WEST SUSSEX COUNTY COUNCIL CONSULTATION

TO:	Arun District Council FAO: Amber Willard
FROM:	WSCC - Highways Authority
DATE:	7 June 2021
LOCATION:	95 Hawthorn Road, Bognor Regis, PO21 2BE
SUBJECT:	BR/142/21/PD Notification for Prior Approval under Schedule 2, Part 3, Class M for the change of use from a shop (A1 shops) to 1 No flat (C3 Dwelling house).
DATE OF SITE VISIT:	N/A
RECOMMENDATION:	Advice
S106 CONTRIBUTION TOTAL:	N/A

Proposed Conversion of Shop to form One Bedroom Flat at 95 Hawthorn Road Bognor Regis
Mrs D Graves

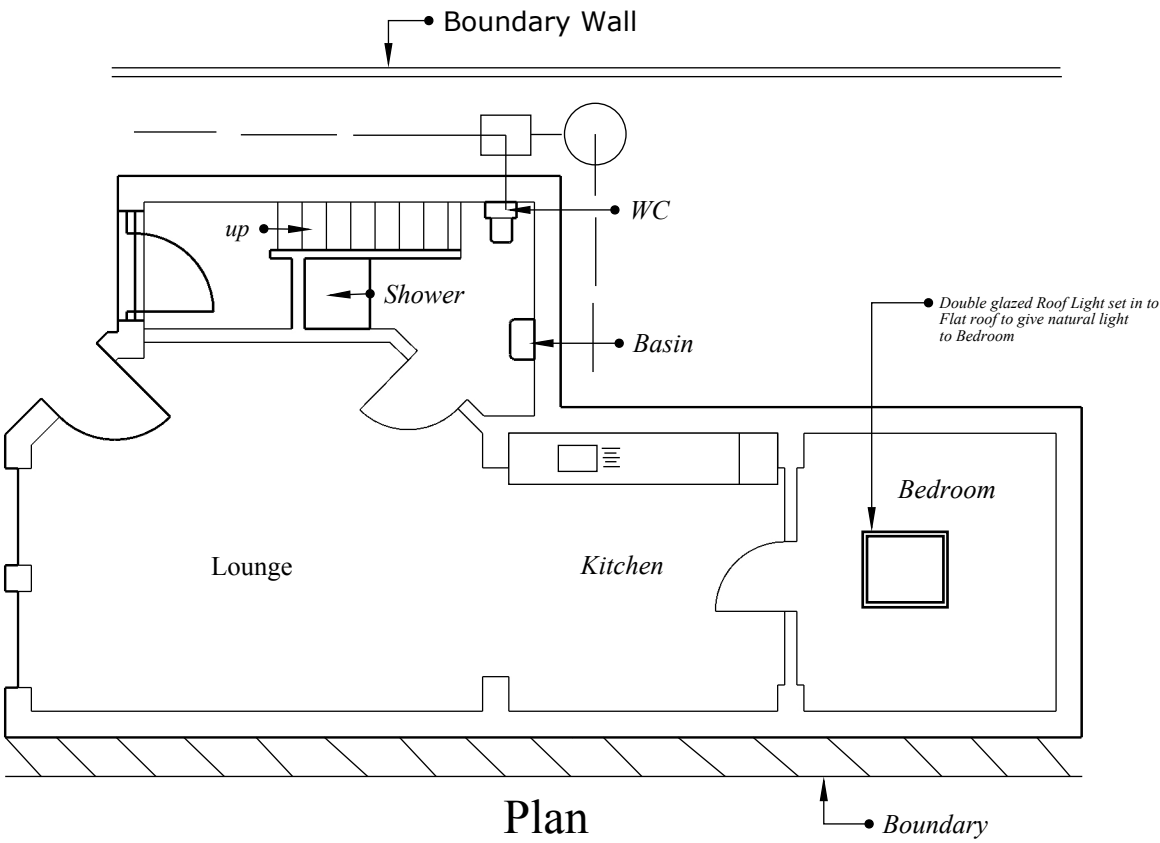
The site is situated in a sustainable location with walking distance of shops, schools and public transport links. Cycling is a viable option in the area and the applicant is advised to demonstrate cycle parking provision, in accordance with WSCC parking standards. The inclusion of secure and covered cycle parking provision will help promote the use of sustainable transport methods.

In principle, the current GDPO gives limited ability to consider wider highway and transport impacts beyond those set out. The proposal is not anticipated to result in a material increase or significant material change in the character of traffic associated with the site. The prior approval is therefore considered acceptable in highways terms. If the LPA are minded to approve the application, the following LHA advises the Planning Authority to condition Cycle Parking.
